Local Policing Support Team

Your Ref: M/68/20/PL

Date 16th September 2020

RE: Poultry Farm 87 Yapton Road Middleton-On-Sea PO22 6DY

Proposed Site Layout Plan

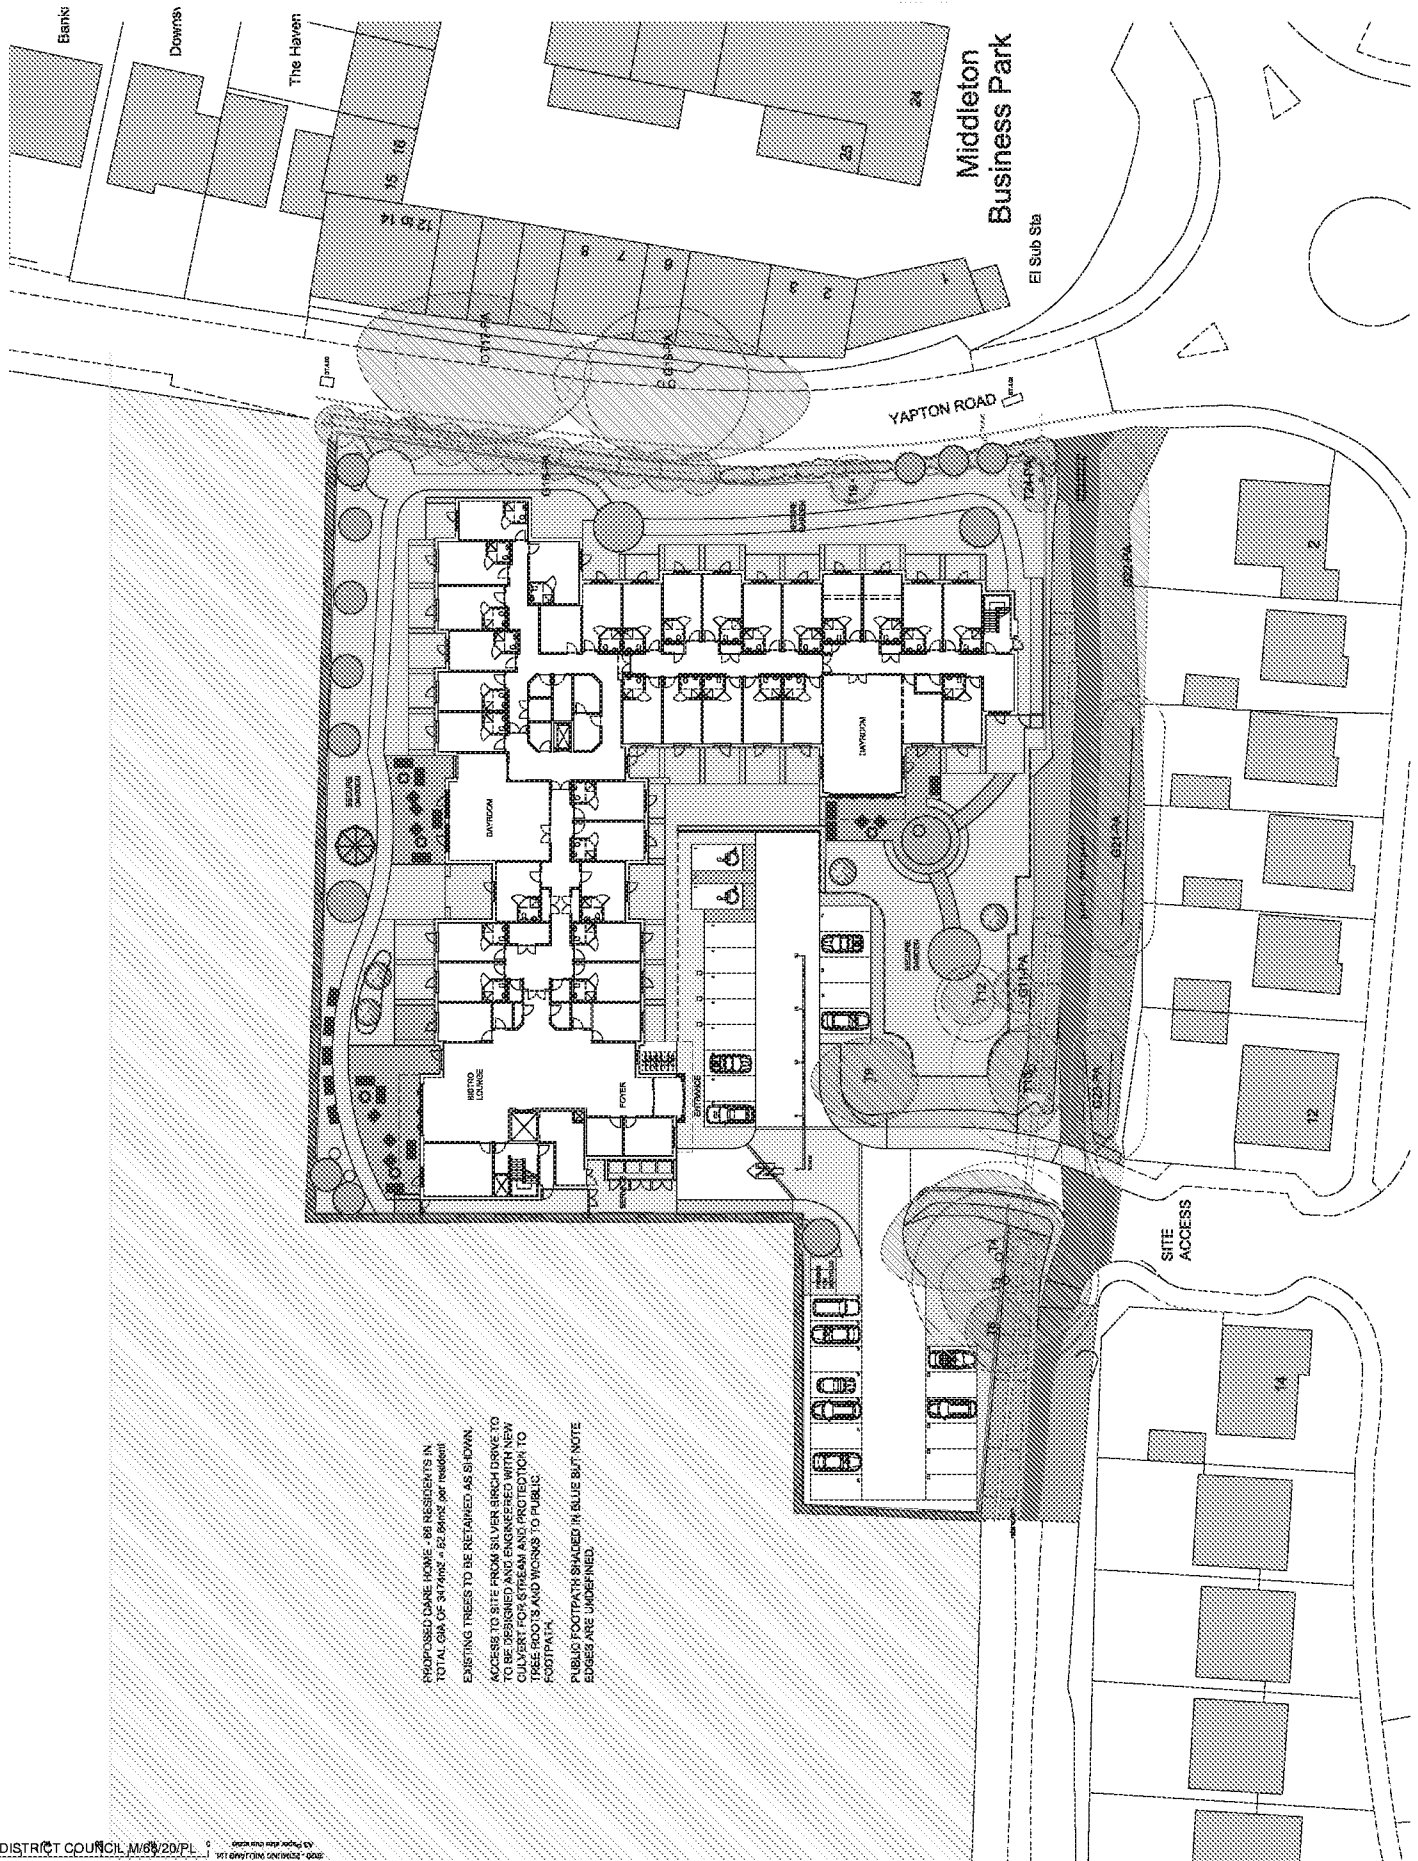
Any parking provision must be illuminated during the hours of darkness. The parking area should also be overlooked and clearly visible from the building where there is a direct and visual connection. Such visual connections can be expected from rooms such as the main reception area and manager's office or communal rooms that are regularly or continually occupied. Staff parking and public parking should be separate and marked accordingly.

The perimeter fencing to the back of the secure garden must be adequate by using fencing to a minimum height of 1.8metres. Gates that provide access to the side of the building or rear access to the gardens must be robustly constructed of timber, be the same height as the adjoining fence and be key lockable from both sides. Such gates must be located on or as near to the front of the building line as possible. There may be circumstances where more open fencing is required to allow for greater surveillance. Trellis topped fencing can be useful in such circumstances.

With regards to the public right of way SBD recommends that public footpaths should not run to the rear of, and provide access to gardens, rear yards or dwellings as these have been proven to generate crime. Where a segregated footpath is unavoidable, for example a public right of way, an ancient field path or heritage route, designers should consider making the footpath a focus of the development and ensure that they are as straight as possible • wide • well lit (within BS 5489-1:2013) • devoid of potential hiding places • overlooked by surrounding buildings and activities • well maintained so as to enable natural surveillance along the path and its borders.
